## Application for a Non-Material Amendment Following a Grant of Planning Permission

Non Material Amendment of Condition 2 of 3/2020/0057 (APP/T2350/W/20/3260383).

Drawing Number Revision
GA_01_PLAN01 -

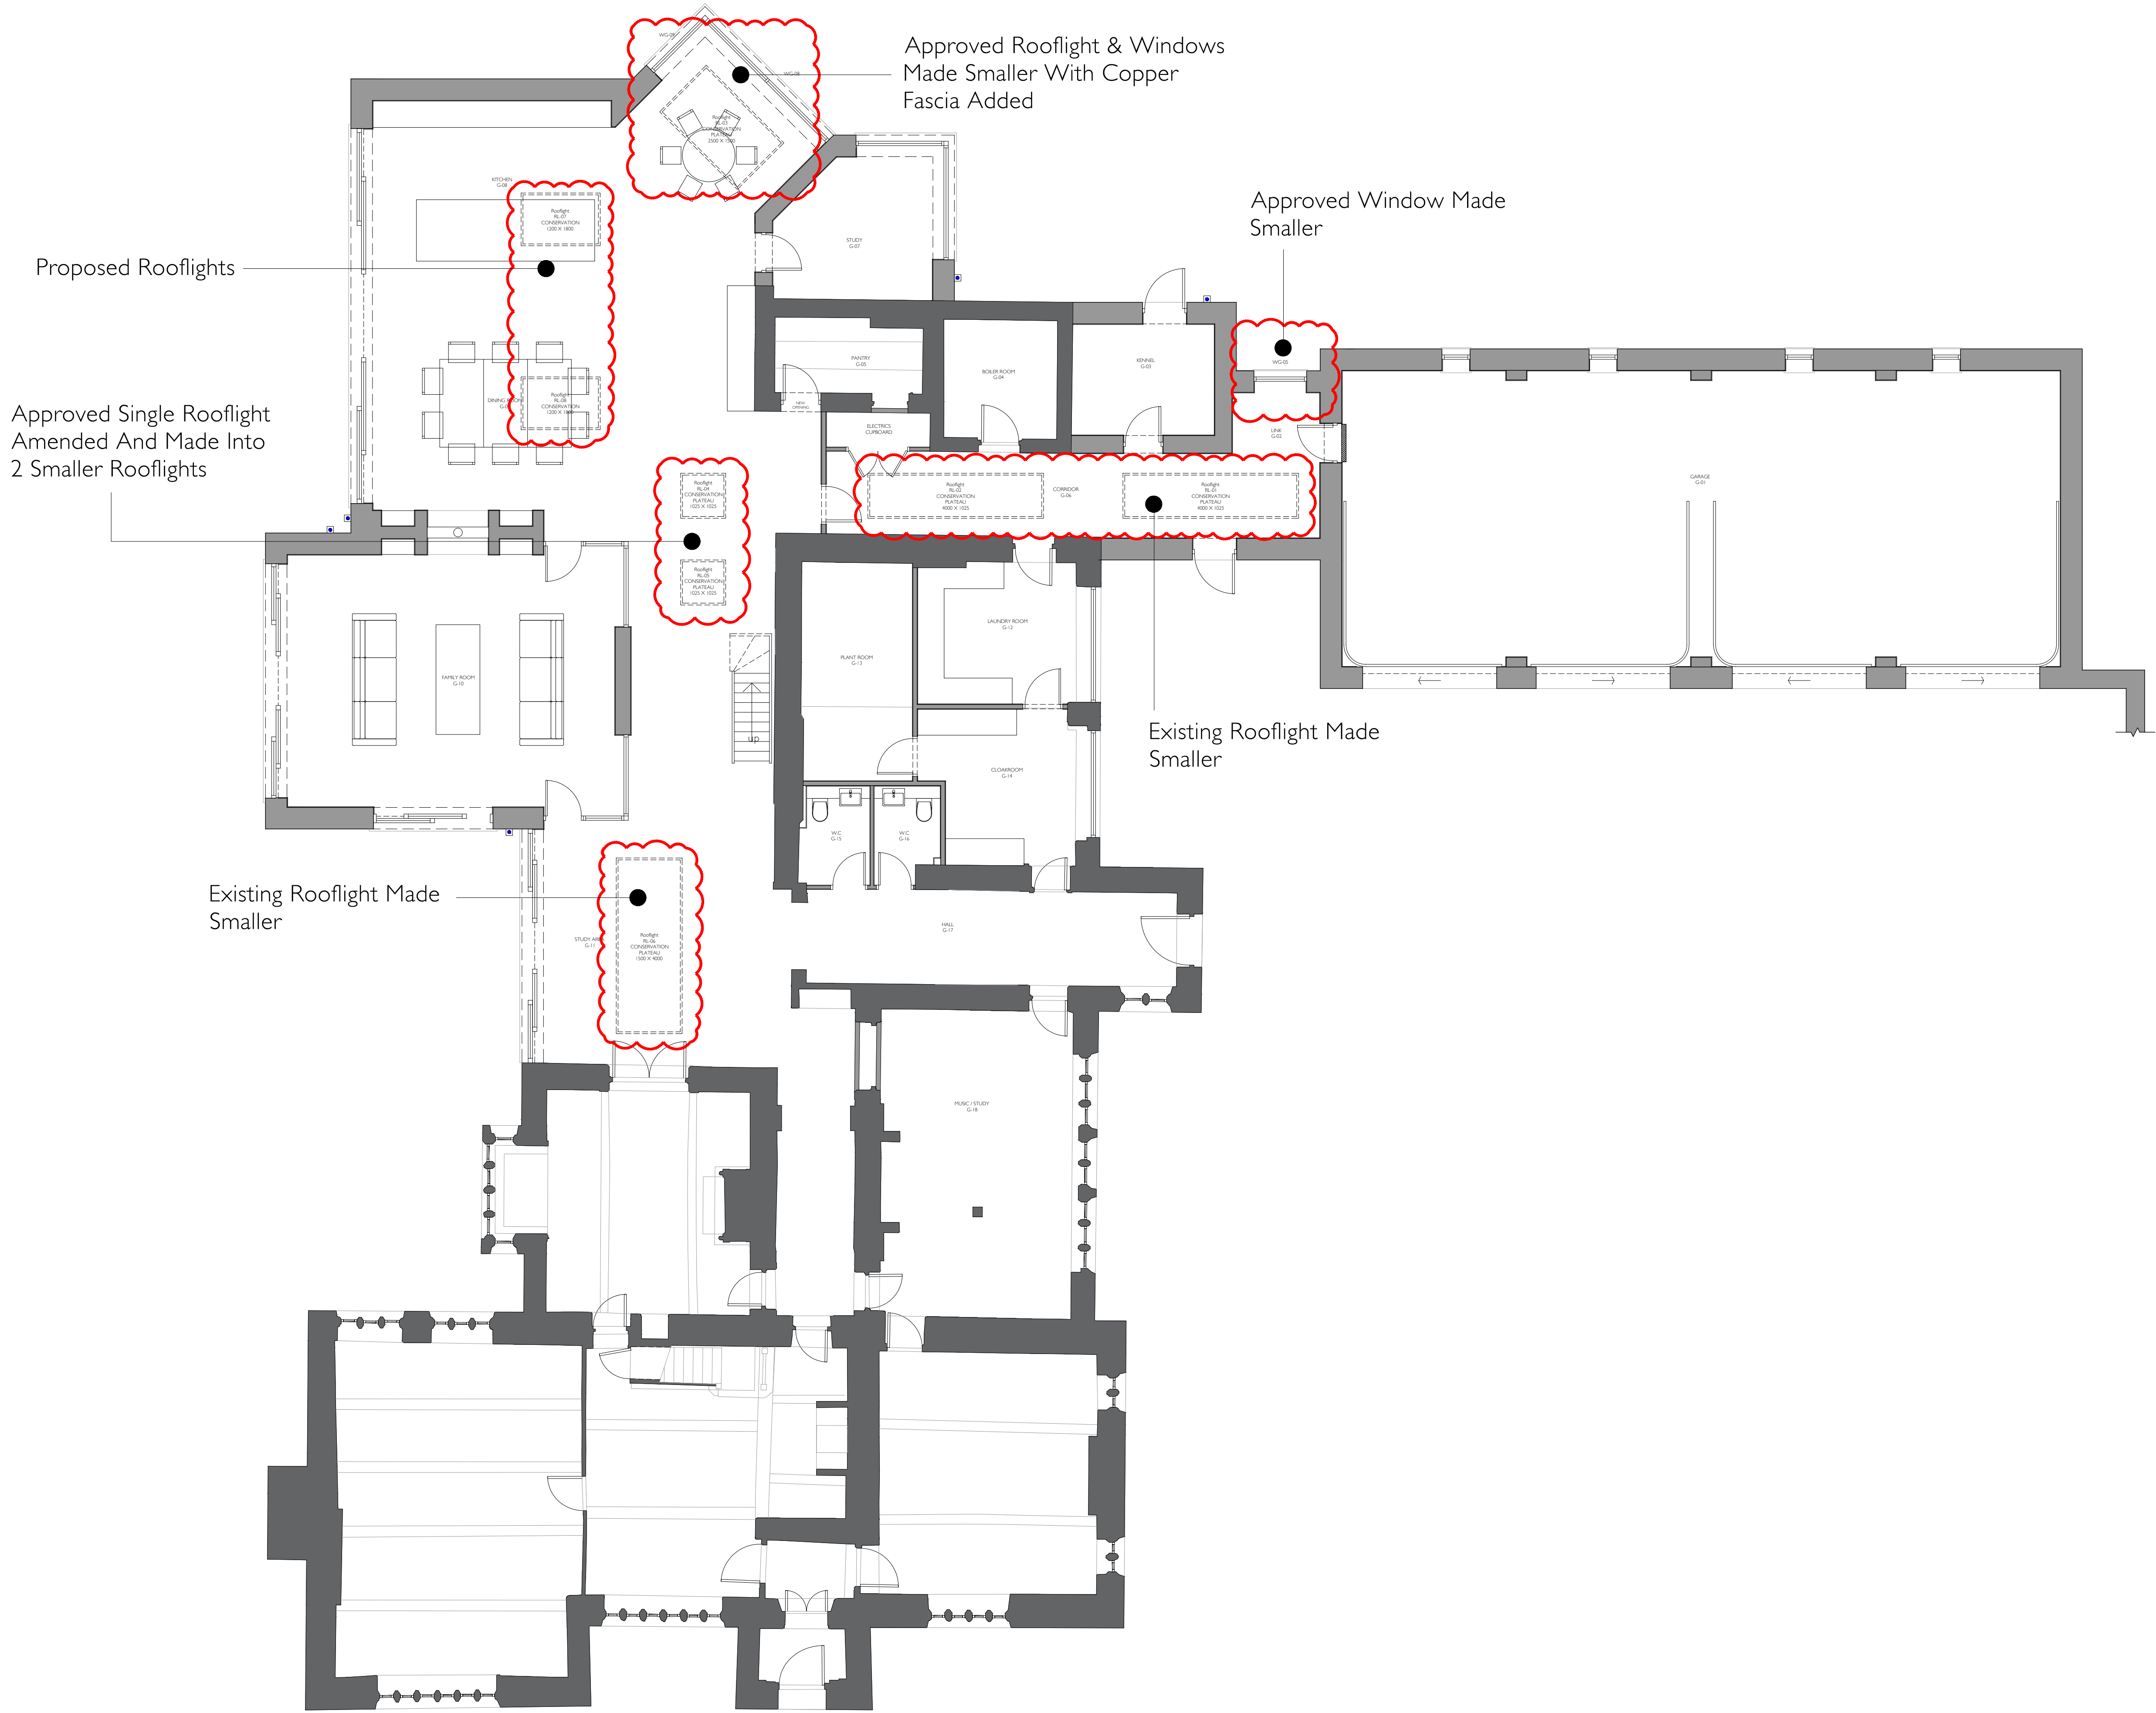
GA\_01\_PLAN01 Ground Floor Roof Lights;
